**Sydney Children's Hospital Stage 1 and Children's Comprehensive Cancer Centre  
(SSD-10831778)**

Thank you for your correspondence via the Major Projects Portal on 17 May 2021, requesting Transport for NSW (TfNSW) to review and comment on the above.

SKT003

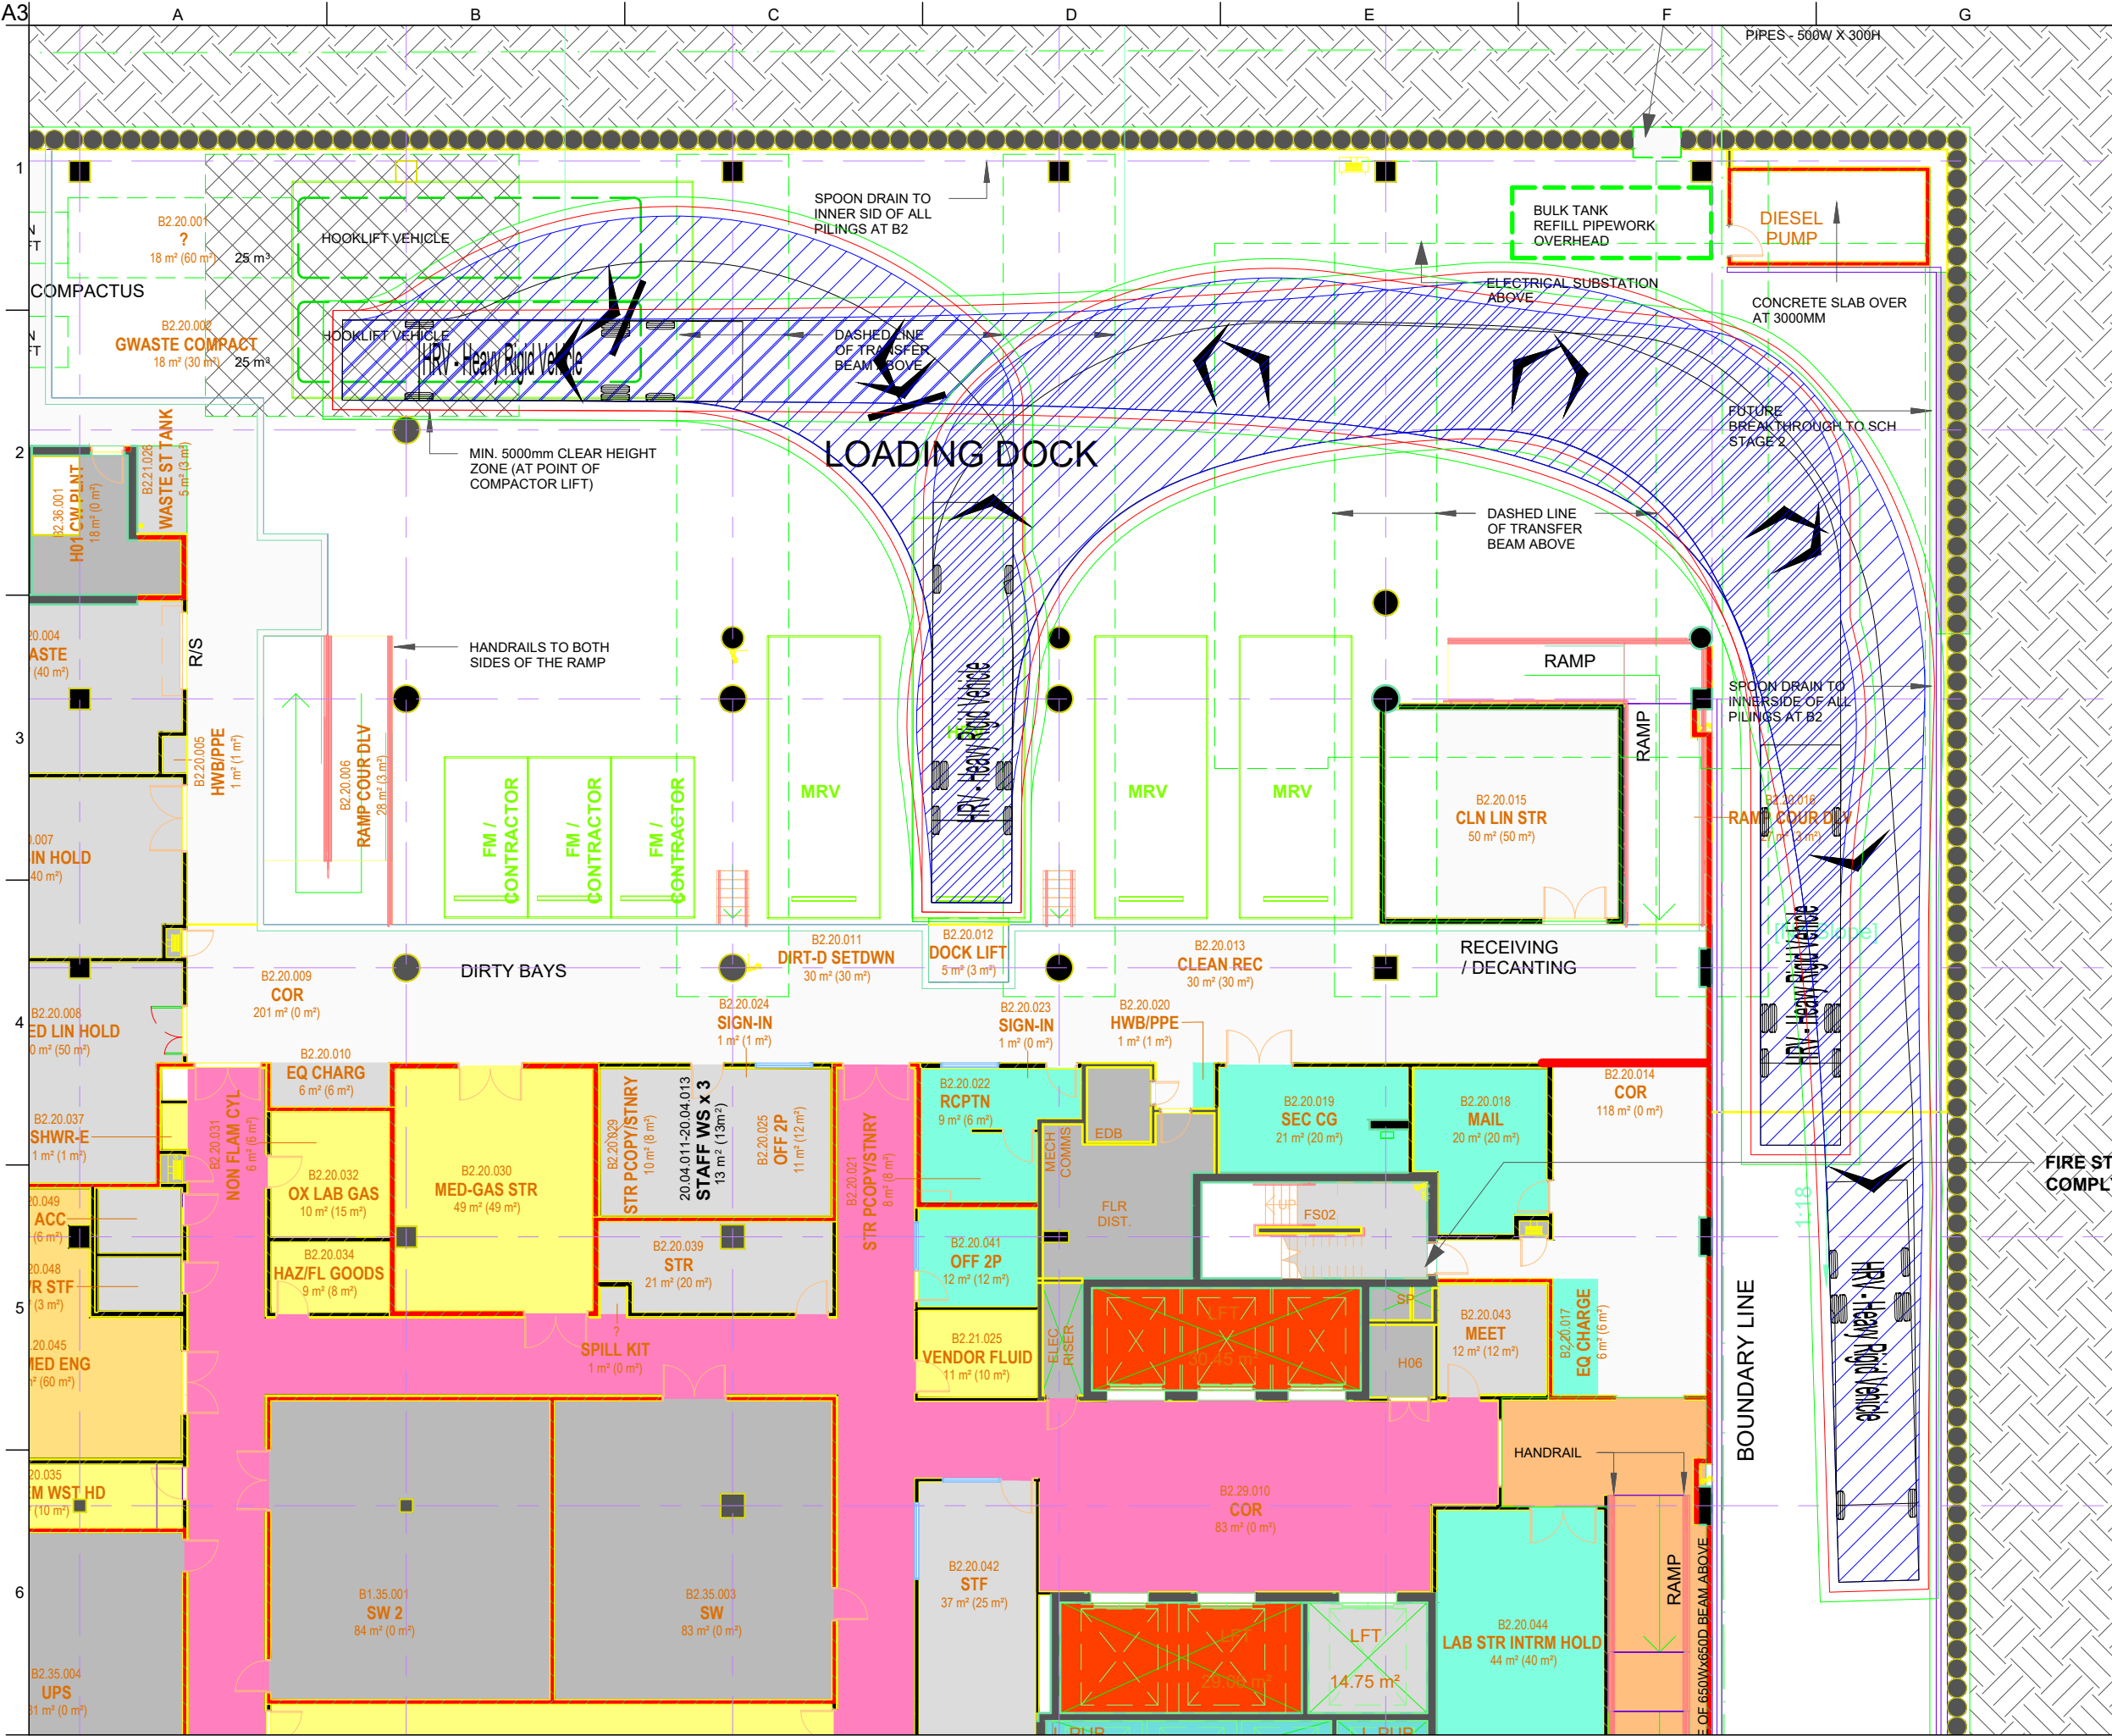
Swept paths analysis has not been undertaken for the maximum size of the vehicle accessing the loop road (Ambulances) via Botany Street in the Traffic and Transport Assessment.

- Consider providing a consolidated loading dock for the subject site as well as the Children's Hospital Stage 1 and Children's Comprehensive Cancer Centre with access via Hospital Road. This is to remove the heavy vehicle access via Botany Street;
- A Stage 2 (Concept Plan) Road Safety Audit for the proposed vehicle and pedestrian access arrangement to the subject site in accordance with *Austroads Guide to Road Safety Part 6: Managing Road Safety Audits* and *Austroads Guide to Road Safety Part 6A: Implementing Road Safety Audits* by an independent TfNSW accredited road safety auditor; and
- A swept path analysis for the maximum size of the vehicle (Ambulances) entering and leaving the loop road to / from Botany Street.
